CITY OF ALBUQUERQUE

Re: Tenant Improvements, BP-2017-30796, BP-2019-14734 & BP-2019-40288
1601 Commercial Rd NE
30-Day Temporary Certificate of Occupancy
Transportation Development Final Inspection
Engineer's/Architect's Stamp dated 5-10-19 (J14D187)
Certification dated 12-12-19

Traffic Circulation Layout

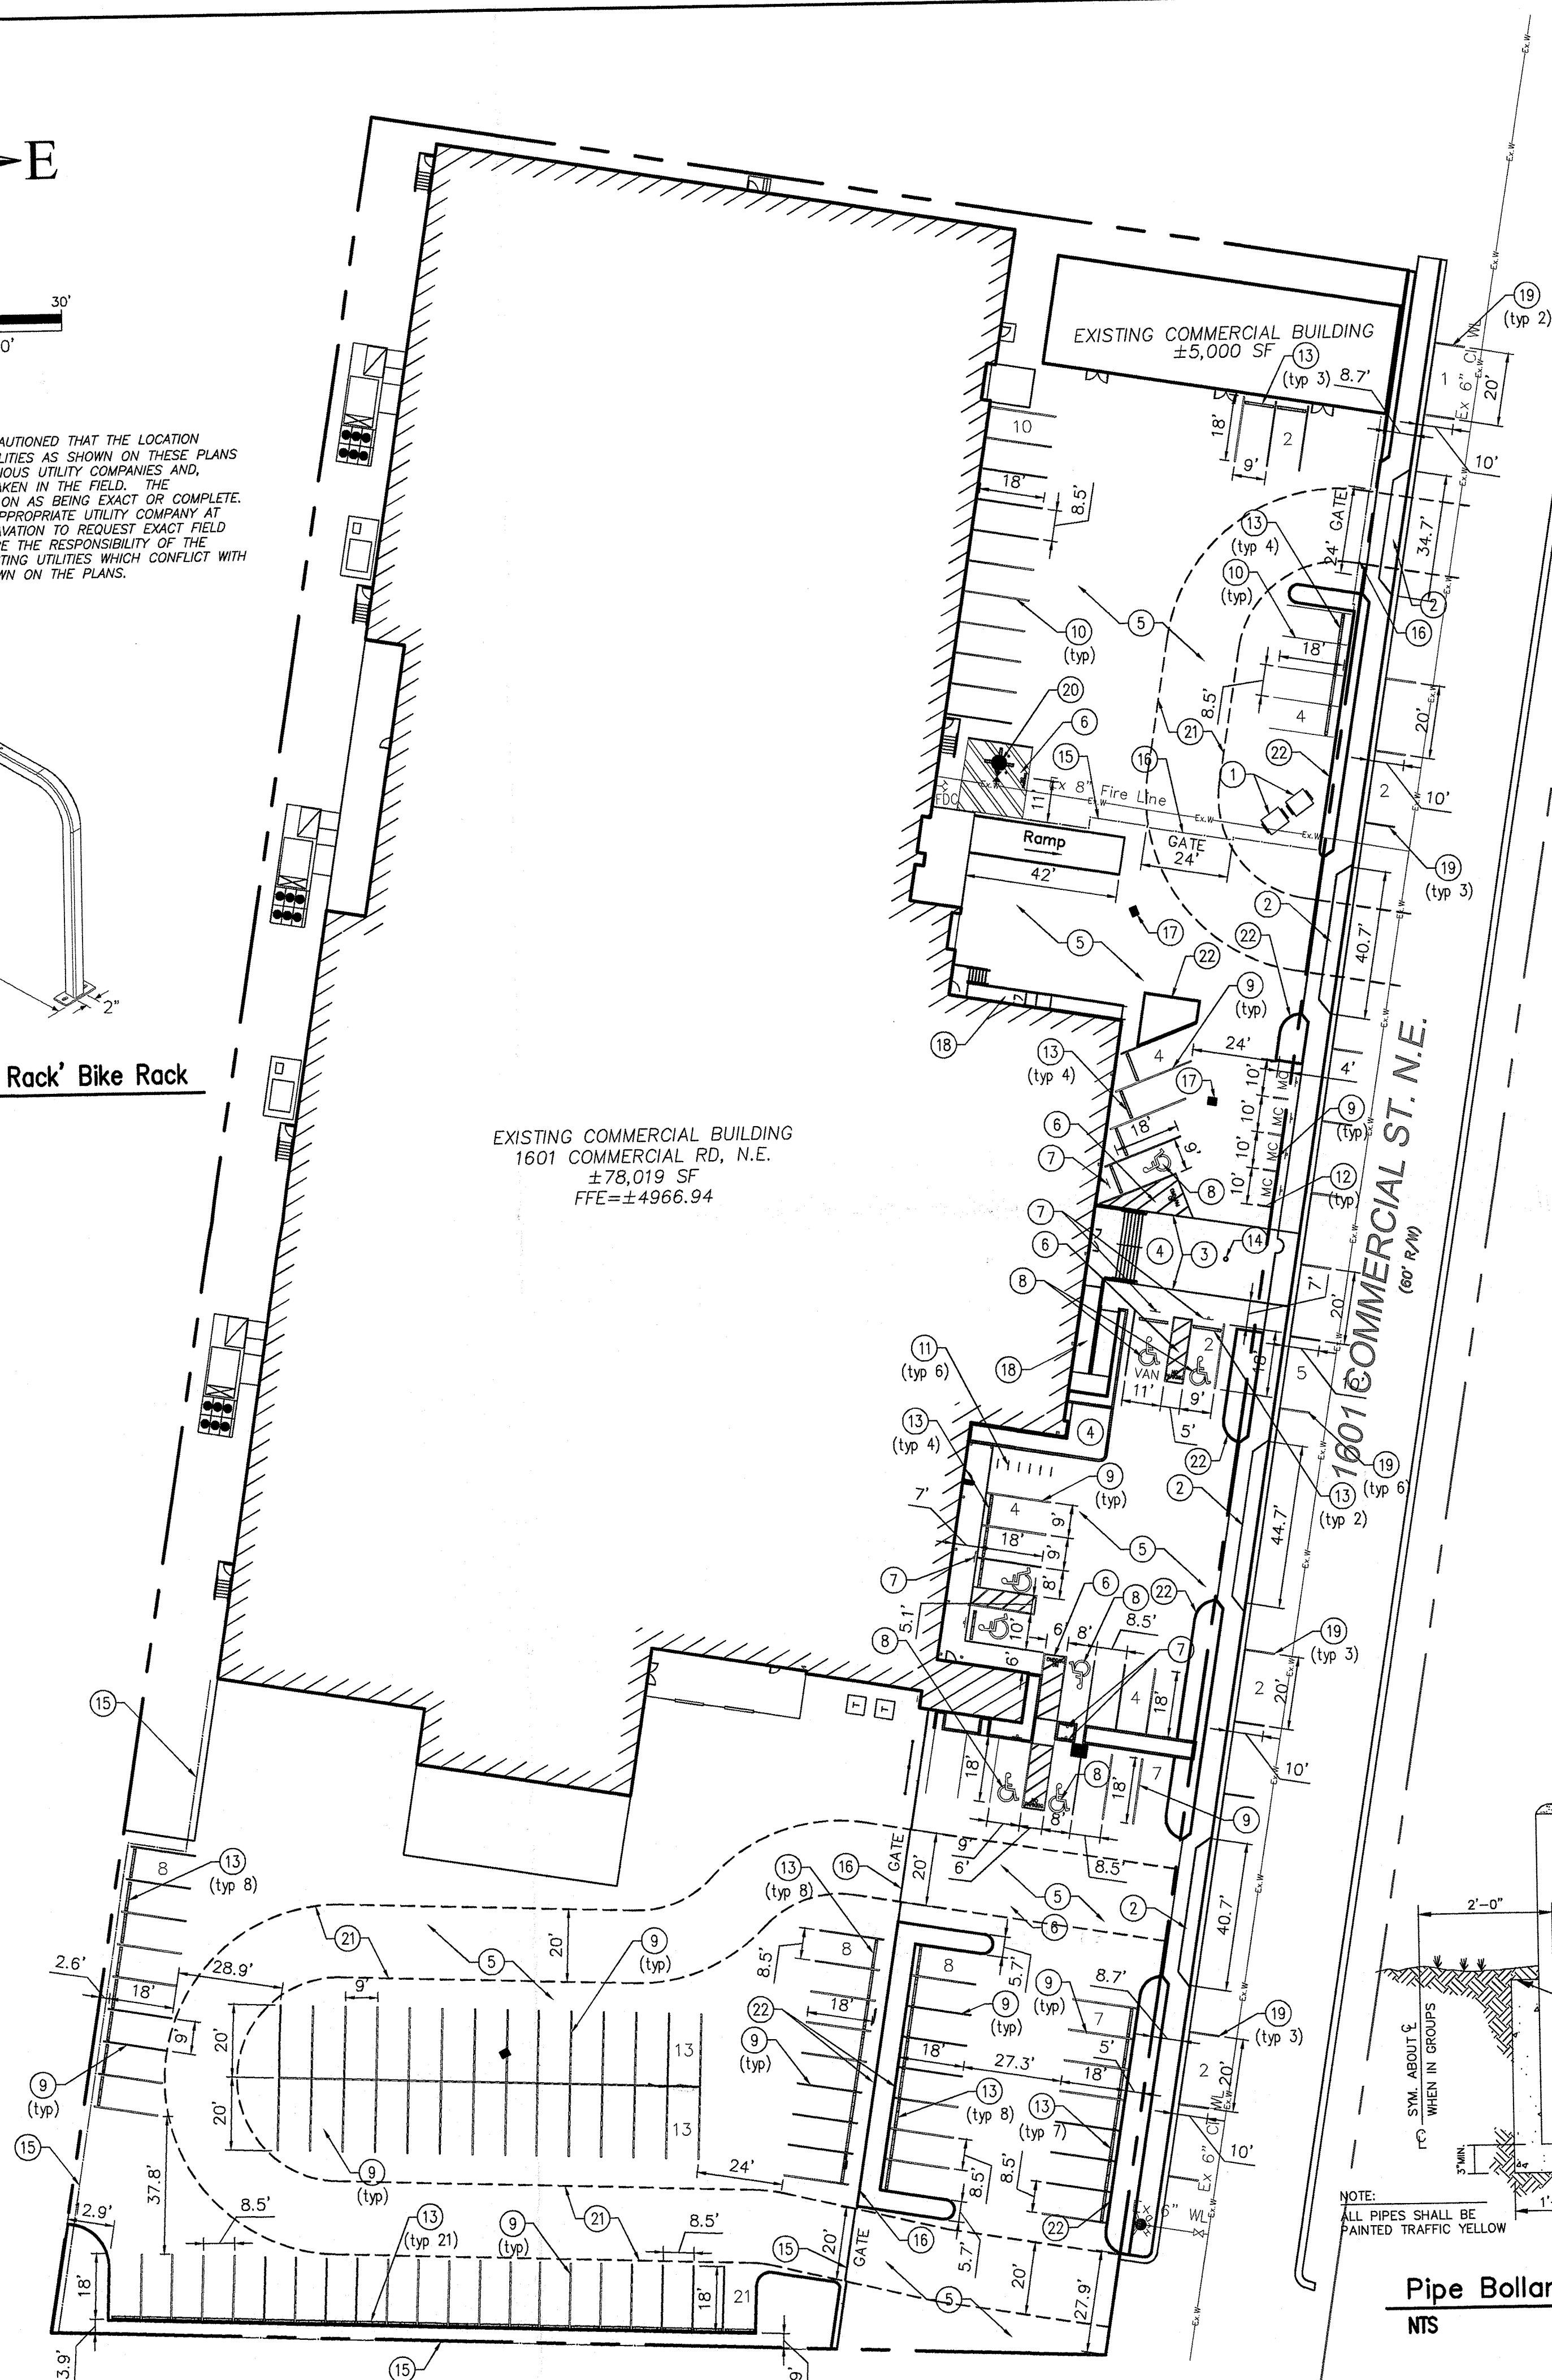
- Each Motorcycle parking space shall be designated by its own conspicuously posted upright sign, either free-standing or wall mounted per the IDO.
- Please remove construction debris and equipment.
- Please stripe ADA access aisle and add No Parking. (See attached photo)
